Our Case Number: ABP-314724-22

Re: Railway (Metrolink - Estuary to Charlemont via Dublin Airport) Order [2022]
Metrolink. Estuary through Swords, Dublin Airport, Ballymun, Glasnevin and City Centre to
Charlemont, Co. Dublin

Re: Submission to "Railway (Metrolink–Estuary to Charlemont via Dublin Airport) Order 2022". ABP Ref: 314724. Deadline 25 November 2022

Our Ref: MetroLink Draft Railway Order – Lidl (re Northwood Site) Consultation Submission

Project: METROLINK	Drawing Title: METROLINK - STRUCTURES NORTHWOOD STATION PROPOSED STREET LEVEL DESIGN	Drawing Status: S0
Drawing N°: ML1-JAI-SRD-MS07_XX-DR-Y-02032	Plan Drawing N°: ML-ST 303 L-M1	
Scales Original Size A1: 1:250	Sheet: 1 of 7

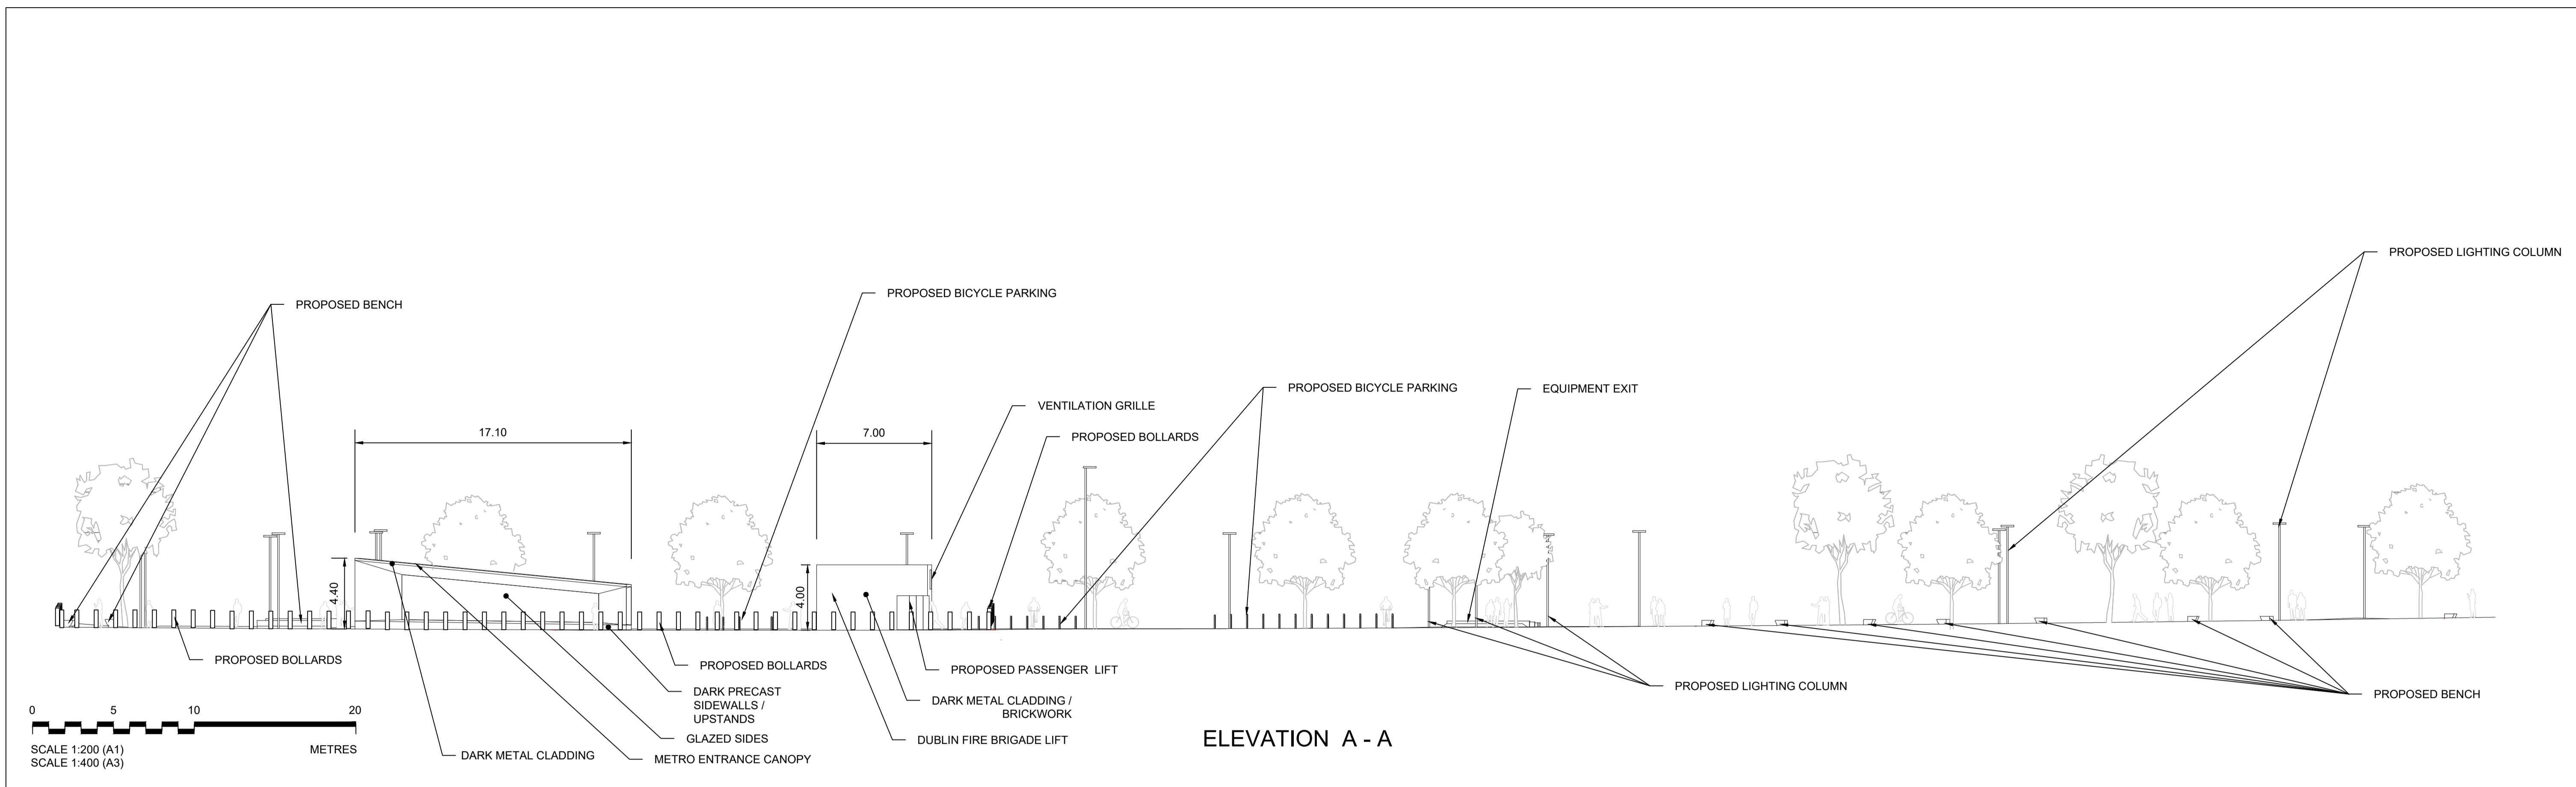
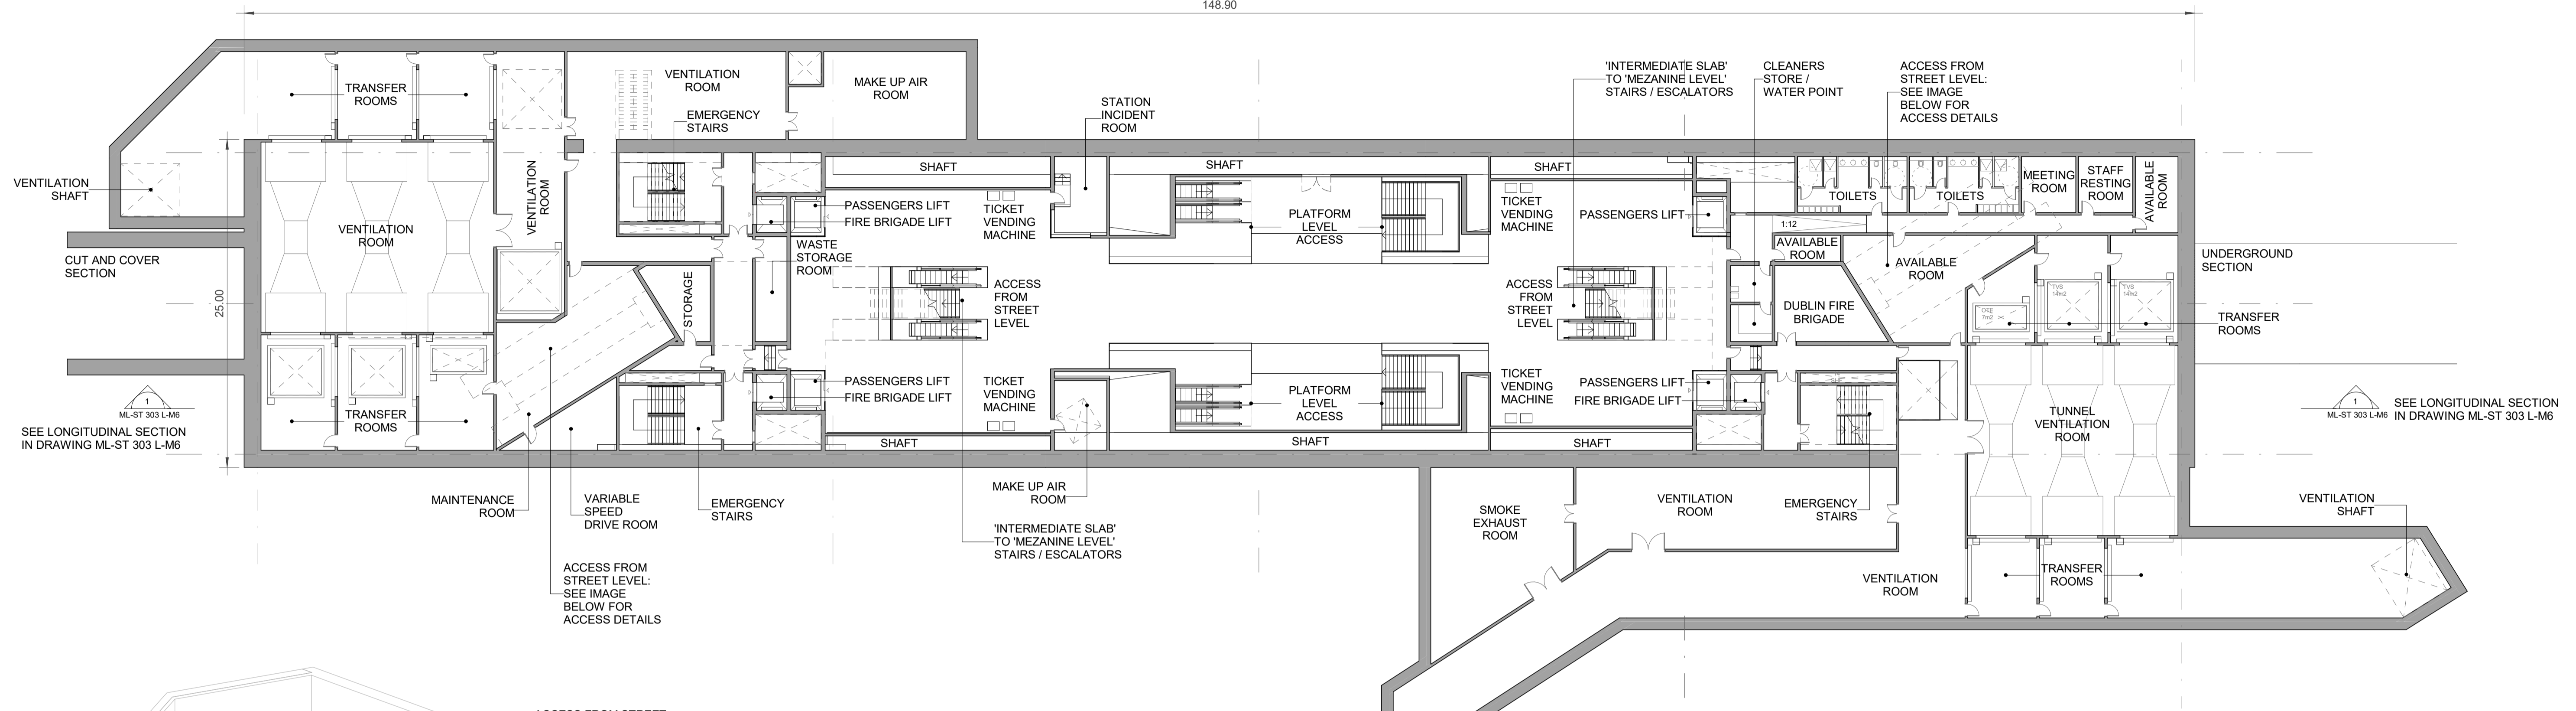
Fundamentally, the proposed MetroLink Plans have a significant and adverse impact on the comprehensive, development potential of the subject lands, in terms of the overall density and floorspace potential. We consider this is fundamentally at odds with the principle of proper planning and sustainable development.

Figure 4.0 below illustrates the approach as shown the Metrolink plans. The area above the station (not the line) will be sterilised with development allowed only beyond the boundaries of the station.

That we consider is the missed opportunity. The plan should be to ensure the station is constructed in such a manner as to allow for development over the station.

The Draft Railway Order is silent on the potential for Over Station Development at this location which we consider a missed opportunity but one that can be rectified within the scope of Railway Order process as the key aspects are not policy based but rather technical in nature.

- **We would therefore ask that over station development is specifically recognised in the Railway Order.**
- **We also refer to the attending report from Transport Insights which sets out additional technical queries that need to be addressed during the application process.**

the proposal would appear to restrict development of sections of the site which abut said footprint. Figure 4 illustrates the proposed temporary and permanent land take for Metrolink.

While the potential for some future development is indicated on the subject site adjacent to the station, no allowance appears to be given for Over Station Development (or over track) within the proposed MetroLink plans. The current MetroLink proposals would likely restrict our Clients' ability to deliver a high density development. It is also noted, in chapter 4 of the EIA *Description of the MetroLink Project* the potential for over site development is to be accommodated on the western side of the Northwood station (site opposite) in the future. Our client would wish to maximise the usable area of their site and would ask that the proposed Northwood station design/ layout be reconsidered to ensure it does not restrict development of the areas to be handed back and that over station development be considered further on the subject site.
